Re: Fifteenth Avenue Business Hub (SSD 6407) – Heritage - response to Liverpool City Council's submission

Please find here a response to the following heritage issues that have been raised by *Liverpool City Council* (LCC) in relation to the exhibition of SSD 6407 (as dated 11 December 2015) and the Aboriginal and historical archaeological assessment prepared for the FABH project by DSCA in May 2015.

**Illustrative Site Plan**

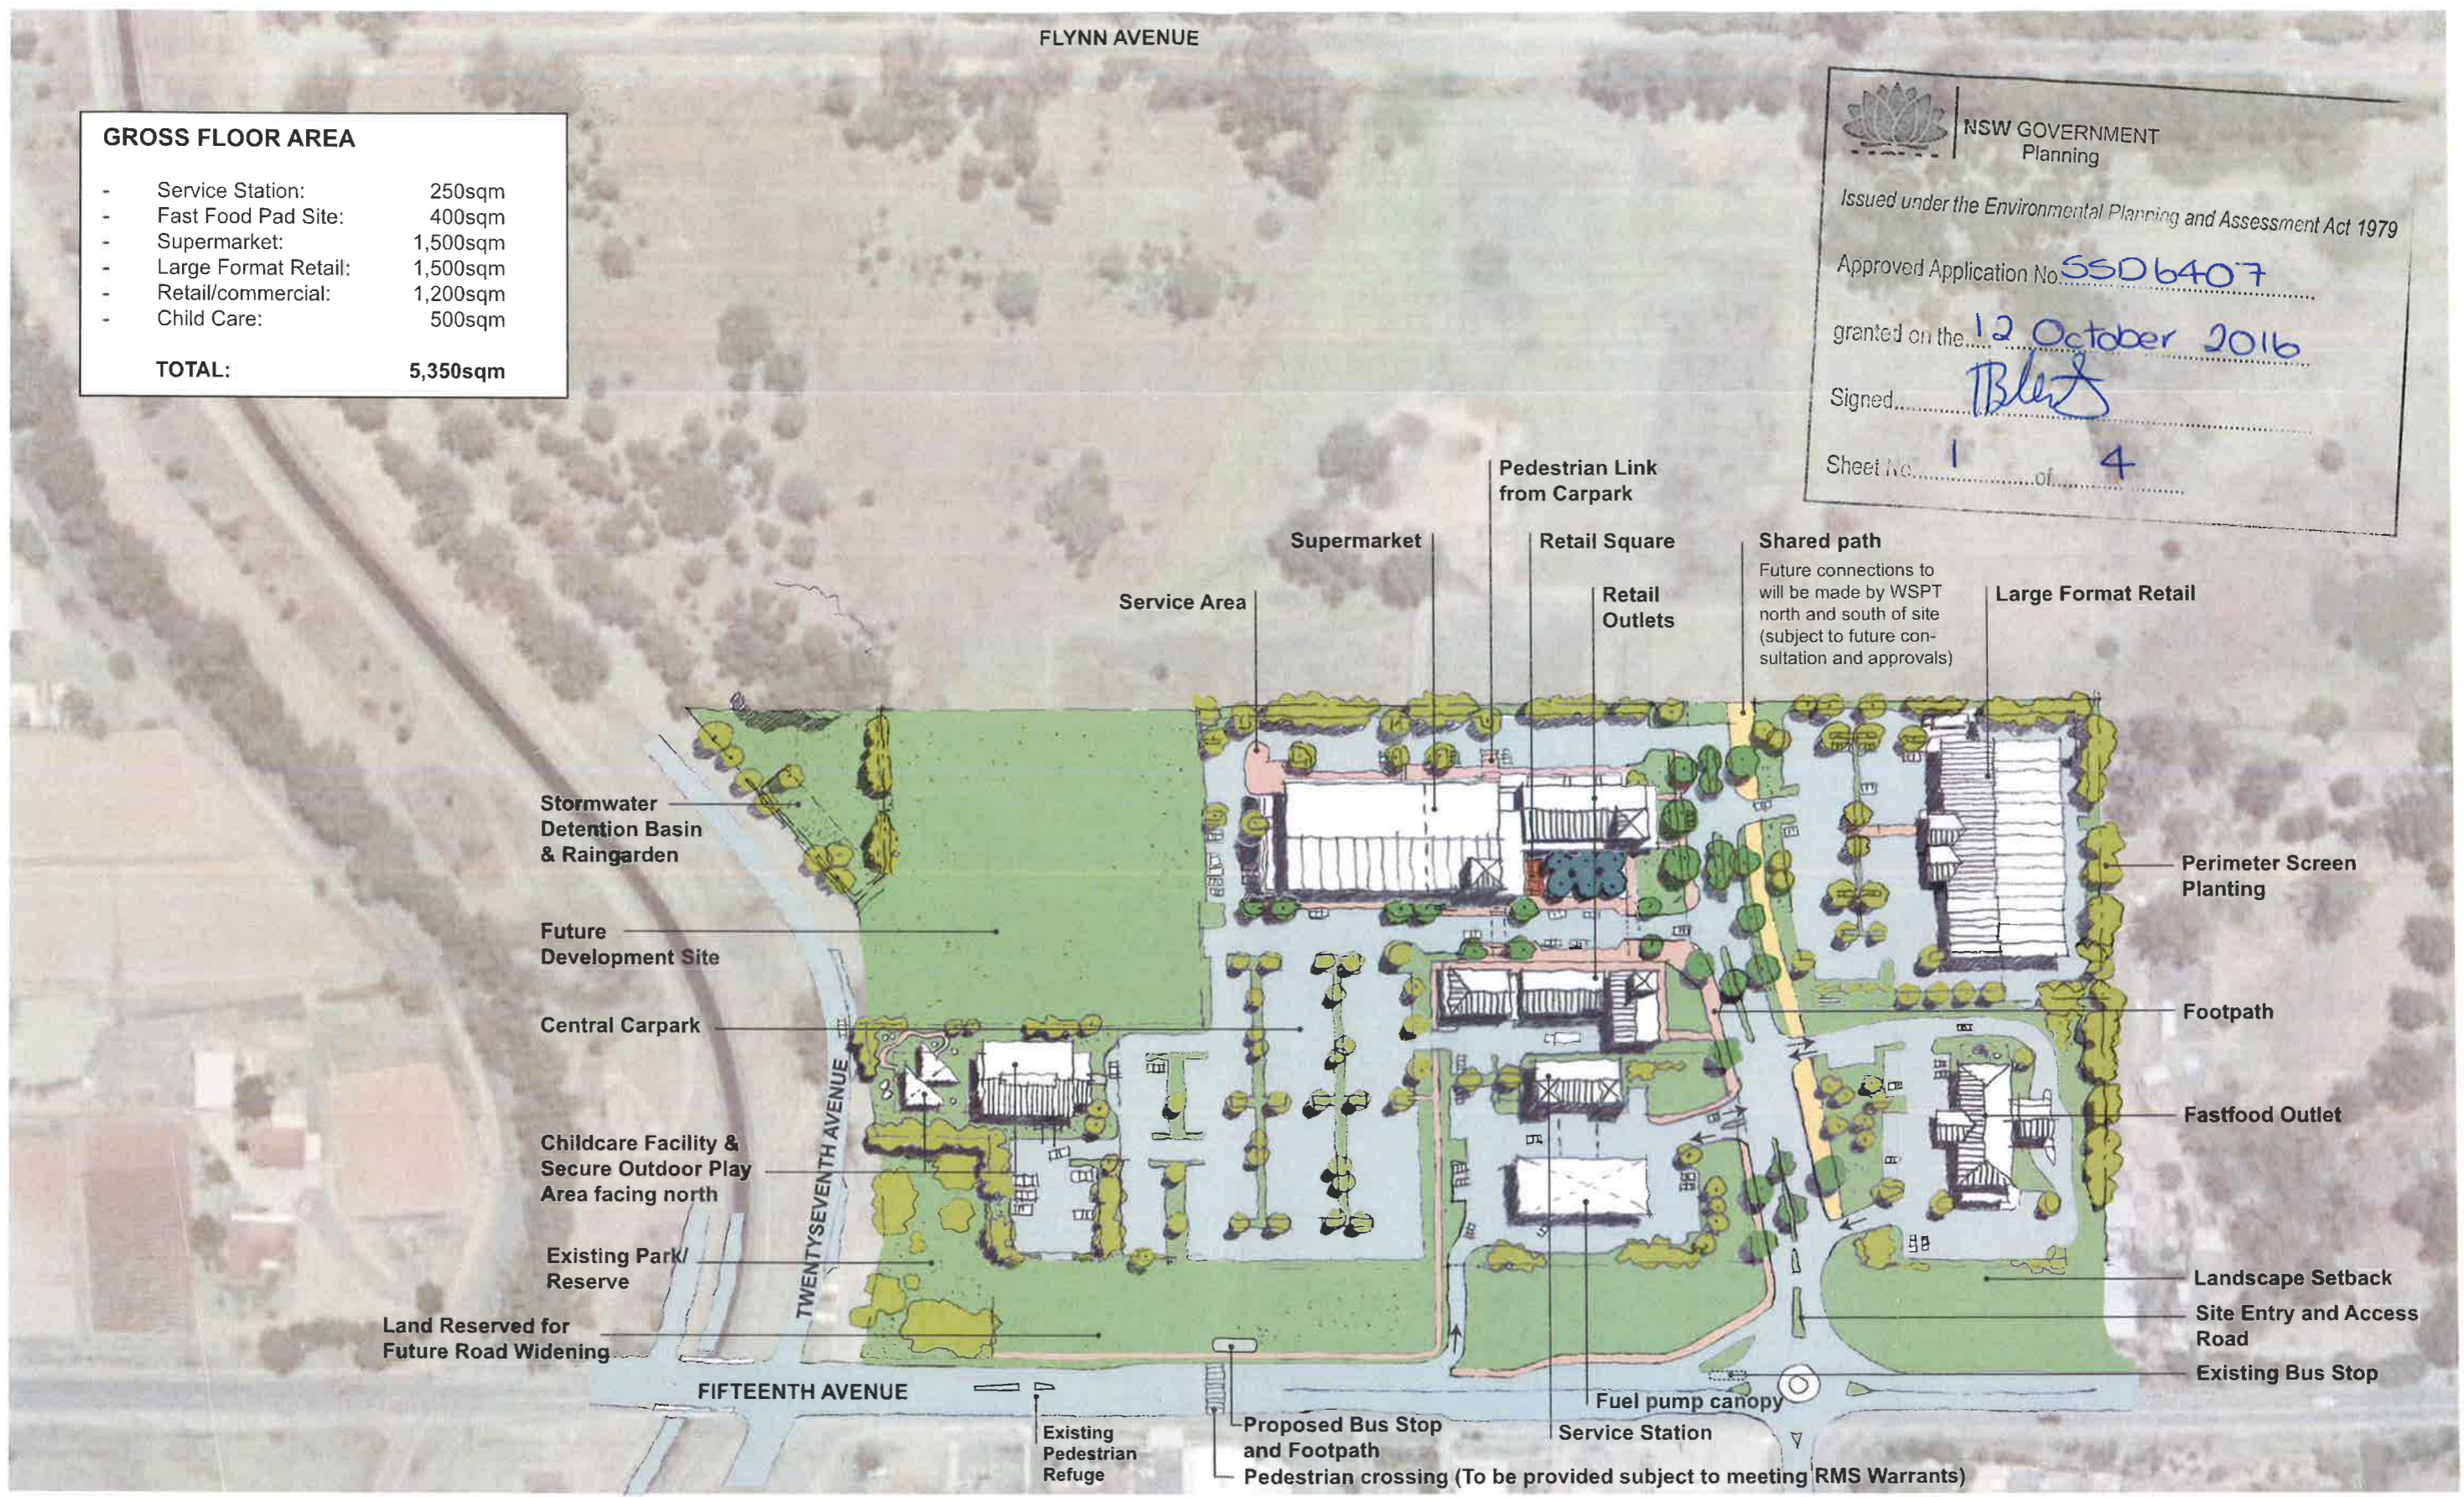
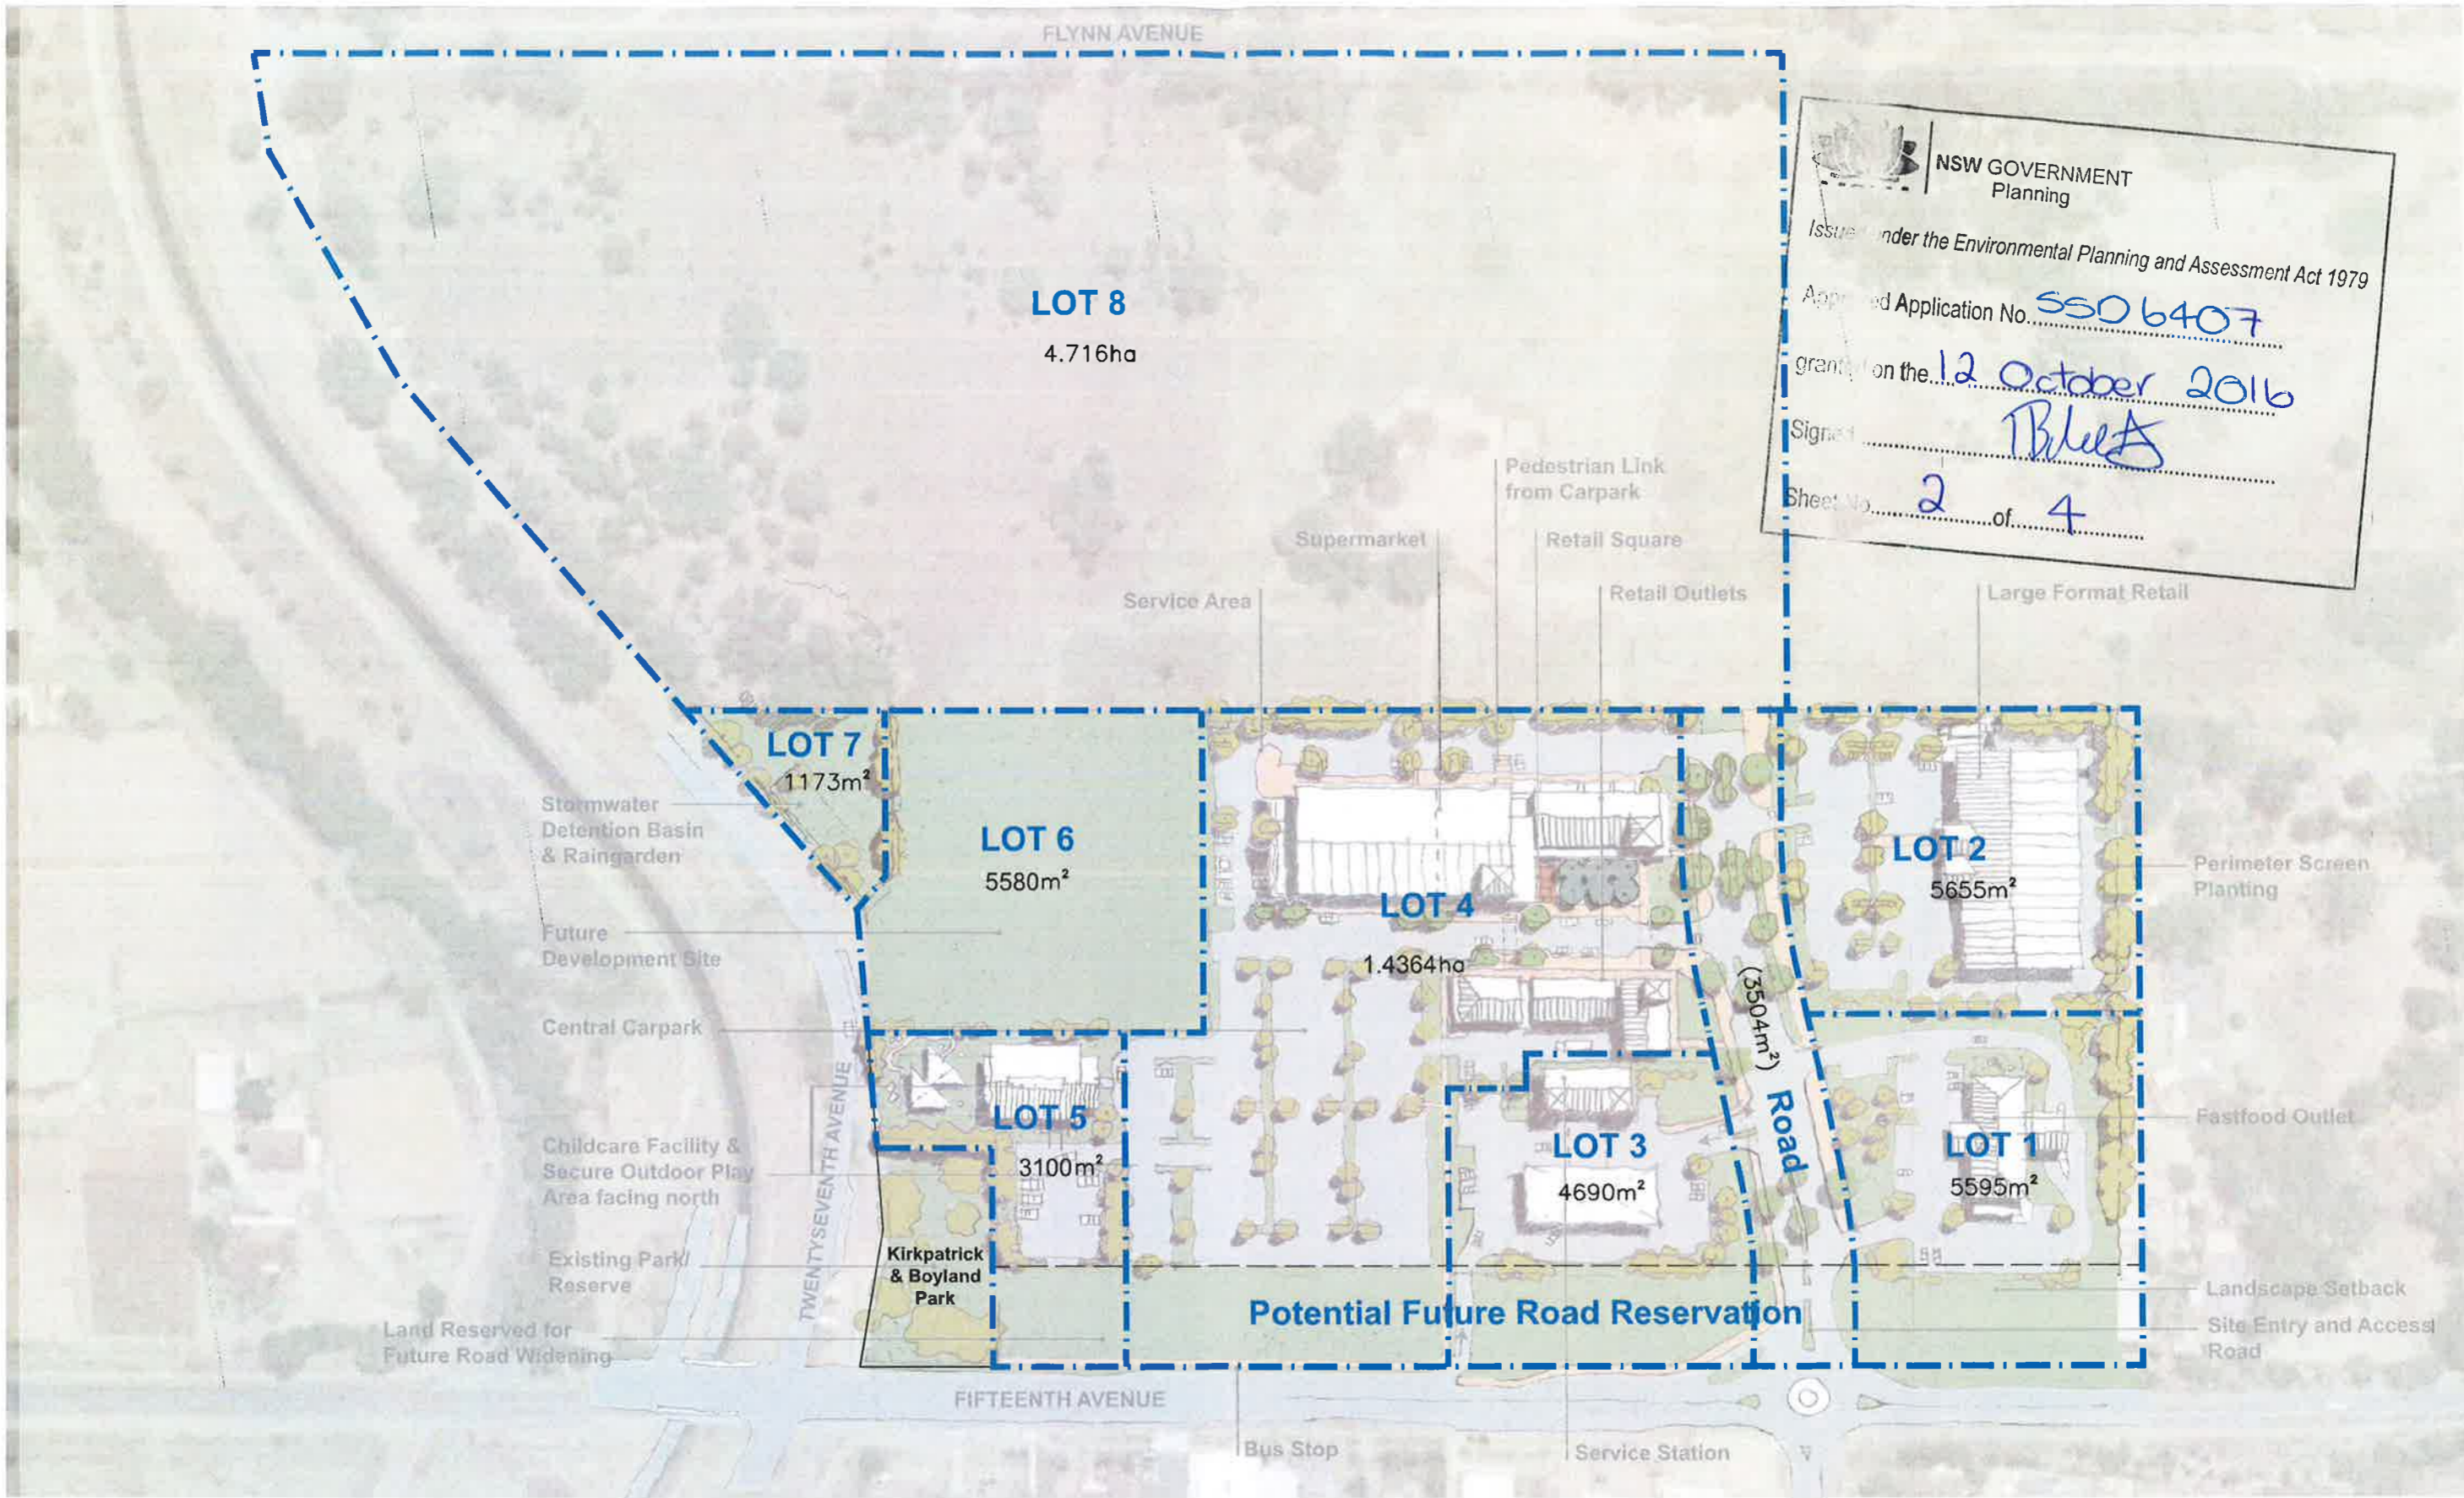
- a) *The planned widening of Fifteenth Avenue will dramatically reduce the size of the heritage listed park.*
- b) *The location of the proposed child care facility in conjunction with the future road widening will impact on the amenity of the park and the public's ability to appreciate and engage with the war memorial situated in the park.*

LCC recommend in order to manage the cumulative impacts of both the subject proposal and the road widening that the proposed child care facility be relocated to the north and should extend no further south than the northern boundary of the Kirkpatrick-Boyland Park and a vegetated buffer incorporated along the eastern boundary of the park. LCC recommend the car park could be extended towards the Kirkpatrick-Boyland Park boundary without impacting significance. LCC also recommend that the following conditions are applied to any consent issued for the works on the site:

LCC's recommendations to manage the cumulative impacts of the FABH proposal and road widening will help mitigate visual and amenity impacts to the setting of the park by relocating the proposed child care facility further to the north (only as far south as the northern boundary of the park) with a new vegetated buffer incorporated along the park's eastern boundary. LCC's recommendation that the car park be extended towards the Kirkpatrick-Boyland Park boundary would also be acceptable on archaeological grounds. There are no expectations the areas concerned (which are heavily disturbed) will contain or retain any archaeological features or deposits of significance.
